Date: 25th January 2023

Application no. 3/2022/1178. Listed Building Consent for reconfiguration of an existing listed property and work to an existing outbuilding within the curtilage to be used as an annexe; resubmission of 3/2022/0684. Knott Gate, Townend, Slaidburn.

Planning Officer (Archaeology)
Historic Environment Team

Proposed Outbuilding

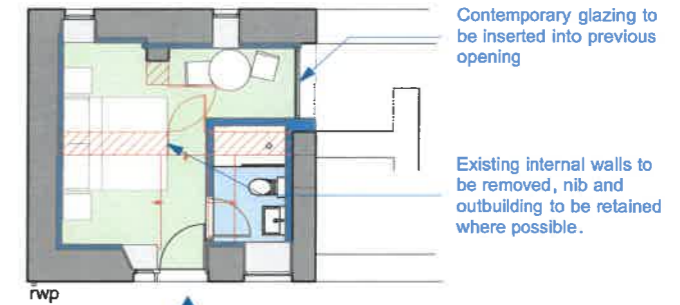
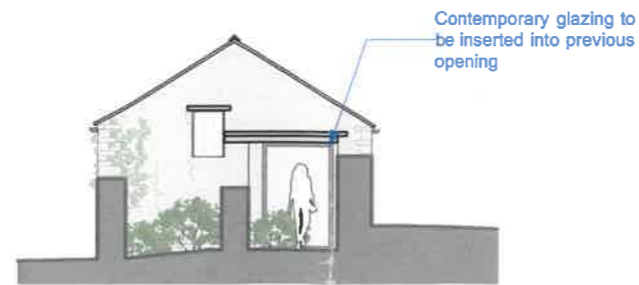
removal of an element demonstrating change and alteration over time. Similarly, if the outbuilding roof also has a stone slab covering, then its loss and replacement with slate (item s) is also more than a minor impact (see also below). It is noticeable that there is no assessment of the condition of these roofs supplied with the application, and it would seem appropriate for such an assessment and further justification for these works to be required by the council. If these works are shown to be justified and the outbuilding roof is of stone (below), consideration should be given to the repair of its roof using the material from the farmhouse, assuming they are of similar materials, rather than replacement with slate.

The proposed re-roofing of the ancillary building (item s) is mentioned above, as is the fact that this roof is described as 'stone' and not slate on the plans 'as existing' and in the Bat Survey. Indeed, in Appendix 5 of the HS the roof is described as '*One of few flag roofs in the Conservation Area*' and '*Has a strong vernacular character*'. It is also stated there that it is likely the earliest roof on site and '*Probably 18C or even 17C*'. Impacts would thus seem to be on the higher end of 'medium' or even 'major' rather than 'minor or negligible'. It would seem appropriate for this roof to be retained and repaired in its present form, if possible. As above it is noted that there is no condition survey of this roof or details of the work proposed. What repair work is required to the roof covering? Are there surviving historic timbers and do any require repair or replacement? Is it intended to insert any underfelt or insulation into this roof as part of the conversion to residential use? Much more detail on the need for this work, what is proposed and a strong justification for any changes should be provided on this aspect of the scheme before it is agreed.

Item (t) also appears to have a more significant impact than that set out in the HS. The complete removal of the '*likely original*' wall of '*probably 18C or even 17C*' date would appear to remove much of the evidence for the origin and use of the building, as would the removal of the present internal fixtures and fabric (item u). The totality of what is proposed would seem to retain only the original external walling, with the roof, floors and

internal plan all being swept away. Items v and w would have lesser impacts, although no doubt some repair, adaptation, and alteration of the exterior door (and other exterior openings) will be necessary, and further details of these changes will be required at some stage. Whilst the creation of a new use for this outbuilding would help ensure that it is maintained and retained, the impact of the present proposals is at least higher 'medium' if not cumulatively 'major' adverse, yet little if any justification is provided. A more appropriate use may be as a workshop/garden and log store, servicing the main house and retaining the present divisions. The council may also wish to clarify if the residential use is intended to be as part of the normal use of the main house or an occasional guest bedroom, or alternatively as a commercial enterprise such as B&B use. The incorporation of a separate gated parking area at this end of the property (item x) could seem to imply the latter.

We would advise therefore that a revised Heritage Statement be presented that covers the elements detailed above and until this is done, or until further information is presented that meets these concerns and we can provide appropriate advice based on this, no decision should be made on the application.

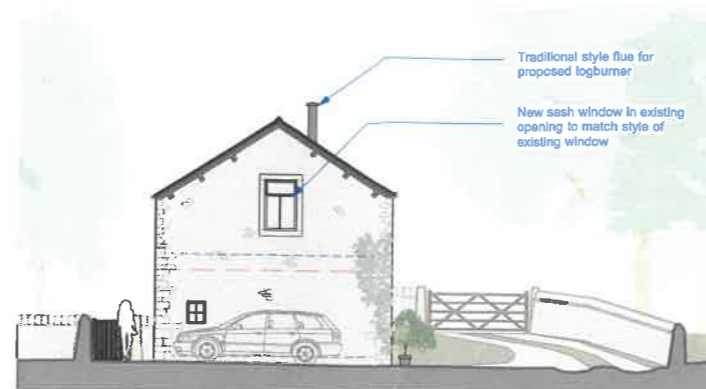
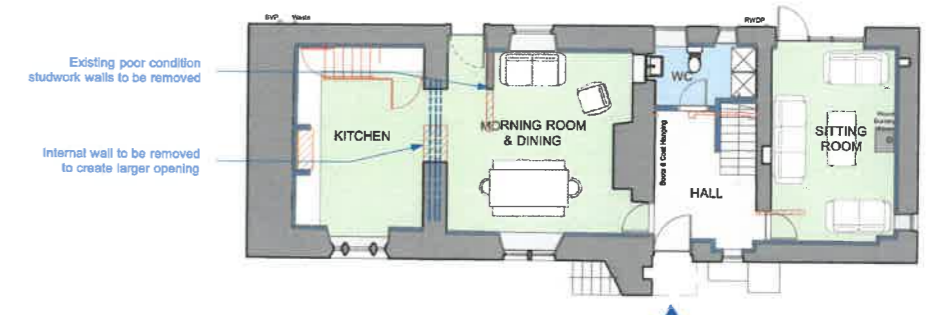
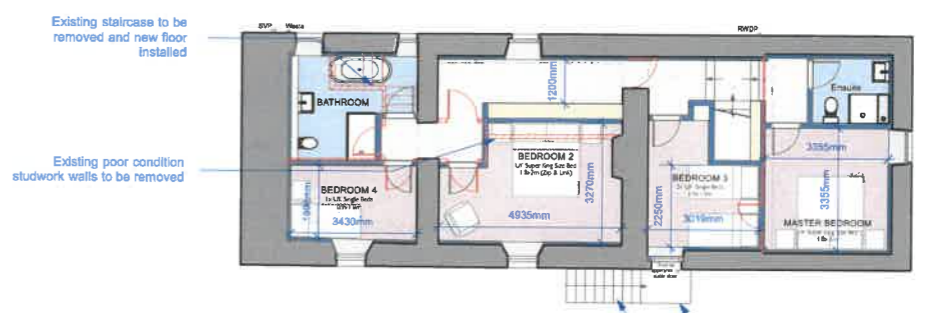
Given the number of stone slab roofs in the Slaidburn area, we would see these as a characteristic of the village architecture. Whilst there is only a section of the farmhouse roof still covered in these, we would be concerned that their removal (item b) is more than a minor impact, representing the final loss of an original covering material and

Items p and q impact the external stone steps on the garden front of the building. The HS notes that the steps are in 'very poor condition', but this is not supported by evidence of a condition survey or appropriate photographs. Because of the way that the stair is cantilevered out of the walling dismantling and reconstruction or repair will not be a simple task and we would suggest that further information on the present state of the stair is required, along with details of the rebuilding work proposed. A method statement for the repair or rebuilding (if found to be appropriate) and the detailed design of the proposed new railing and balustrade will need to be agreed with the council.

The replacement of the present garage door (item r) with a three-section wood and glass 'French window' would appear to have more than a 'negligible' impact on the appearance of the Listed Building (HS Appendix 5) and may suggest that the opening is not an original feature of the building (noted in the HS as 'legibility'). Whilst the desire for this change is understandable, a more 'agricultural' and less 'gentry house' design may tone-down its visual impact and signpost more of its original function. The loss of the present sliding door (and its associated mechanism) is however not considered to be particularly serious.

Proposed Ground Floor Plan
Scale: 1:100

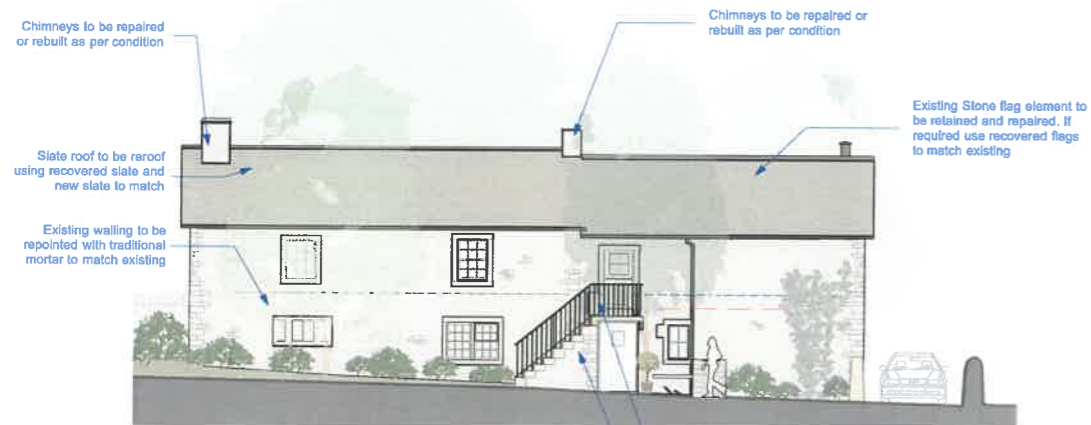
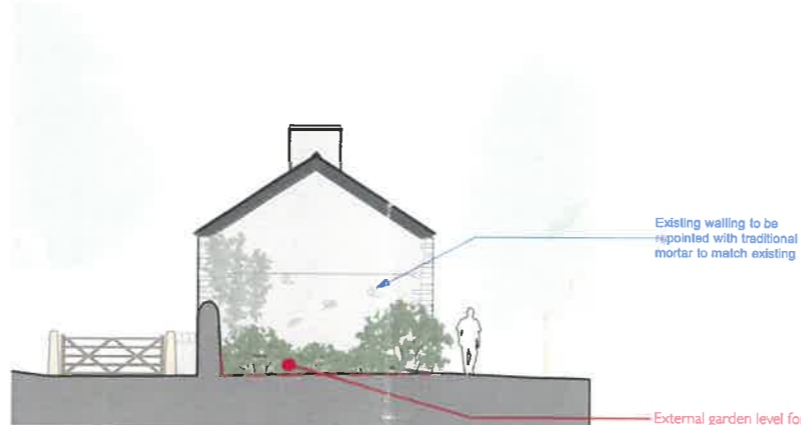
The removal of some of the modern stud walling and its replacement in different configurations (items f, g, and h) is not necessarily harmful in itself, and the majority of the proposed works do not seriously affect the plan form or circulation pattern of the building.

The removal of the studwork from the present porch (item j) and the associated changes to the stairs (items l and m) however will result in the 'reversal' of the house to use the present door under the rear stone stairs as the main door and promoting the 'garden front' to primacy over the 'road front'. This, along with the proposed demolition of an original stone wall to form a modern 'kitchen diner' (item k) will make a considerable change to the existing plan form and circulation pattern of the building, nor do these works attempt to recreate an historic plan form. We would also have concerns about the stability of the first-floor part of the stone wall and the alterations to historic ceiling/floor beams required consequent to the removal of the ground floor portion of the stone wall. Historic England Advice Note 2 '*Making Changes to Heritage Assets*' (2015) states:

Given that the "early core of the property – a 17th century stone-built two-cell structure..." (HS summary) is recognised as a major feature of the building, it would seem that these changes are more than the 'negligible' and 'minor' impacts set out in Appendix 5 Table 6 (but omitted from 6.4.3). They would appear to approach the level of 'major adverse' set out in Appendix 4, Table 4. They require both further investigation and a more detailed assessment of their impact along with strong justification before they should be accepted.

The removal of a 1970s fireplace (item n) is not in itself likely to cause a significant impact, but the complete loss of a visible fireplace from the historic core of the building may well be quite significant. This item is not apparently described or illustrated in the HS nor is its significance as an indicator of a historic fireplace location assessed. It may prove acceptable for the modern elements of the fireplace to be removed if the former presence of a fireplace can still be signalled, although the plans suggest that there is no protruding chimney breast here. The impact of the loss of the fireplace on the flues and chimney above – there appear to be no other fireplaces serving it – also needs consideration. Would it be practicable or desirable to re-use a redundant flue for the SVP for the bathroom at this end of the building and omit an external pipe?
